From: Laura Gibbons <Laura.Gibbons@arun.gov.uk>
Sent: 05 August 2021 08:18
To: Michael Eastham <Michael.Eastham@arun.gov.uk>
Cc: Planning.Responses <Planning.Responses@arun.gov.uk>
Subject: RE: [Hydrock: 19873-SBNO] RE: Planning Consultation on: BE/92/21/DOC

We have reviewed the latest information that was supplied on the 27th July, we do not recommend discharge of condition 15.

Description of Works: Approval of details reserved by condition imposed under hybrid application BE/135/18/PL relating to Full Condition Nos 9 - travel plan, 15 - as built drawings of implemented scheme together with a completion report prepared by an independent engineer and 41 - acoustics and Outline Condition No 17 - badger survey.

UNIT 2 DRAINAGE LAYOUT
SHEET 2

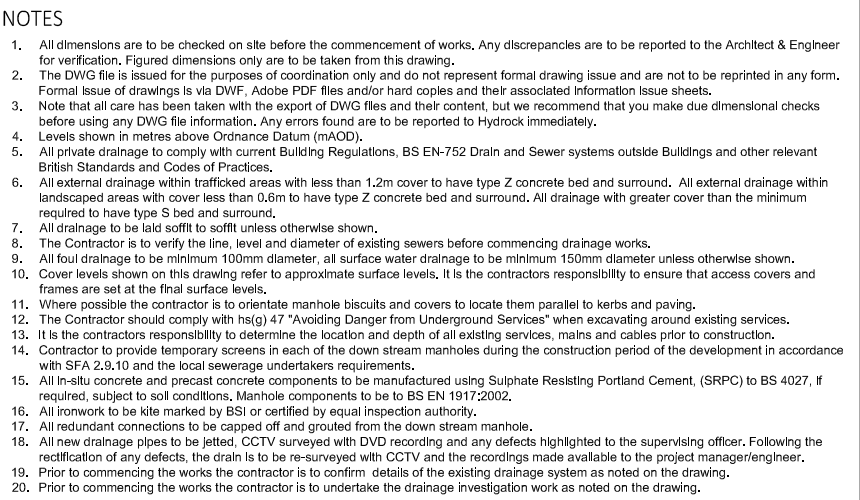
2. *The as built survey doesn't include the invert level of the storage features. Please include this.*

HYD: The as built survey has be updated to include invert levels of storage features. It appears that these have been taken from the design, rather than from survey. The information shown does not tally with your surveyed inverts etc. E.g. the highways drainage network. At SW-505 to 505b with constructed inverts of 0.903-0.723, designed inverts were 0.65, your crate on the as built is labelled as having a constructed invert of 0.65. Either this is incorrect or you are under providing on your storage as the base of the crates will permanently have water in. Please provide as built information.

4. ***There are numerous pipes on the as built drawing which do not include pipe fall or diameter. Please ensure that all pipes are labelled with diameter and fall.***

HYD: The as built drawings have been updated to include the information as requested. I query whether this is in fact as built information. For example the design for the pipe between SW503 and SW504a was for a 450 diameter pipe at 1:380 falls, this has been indicated on the as built. However, the upstream and downstream as built invert levels are inconsistent with design, given the elevation difference is different (0.38m designed 0.288m constructed) it is not clear how the fall can be the same when manhole positions appear consistent. The same applies elsewhere throughout the network.
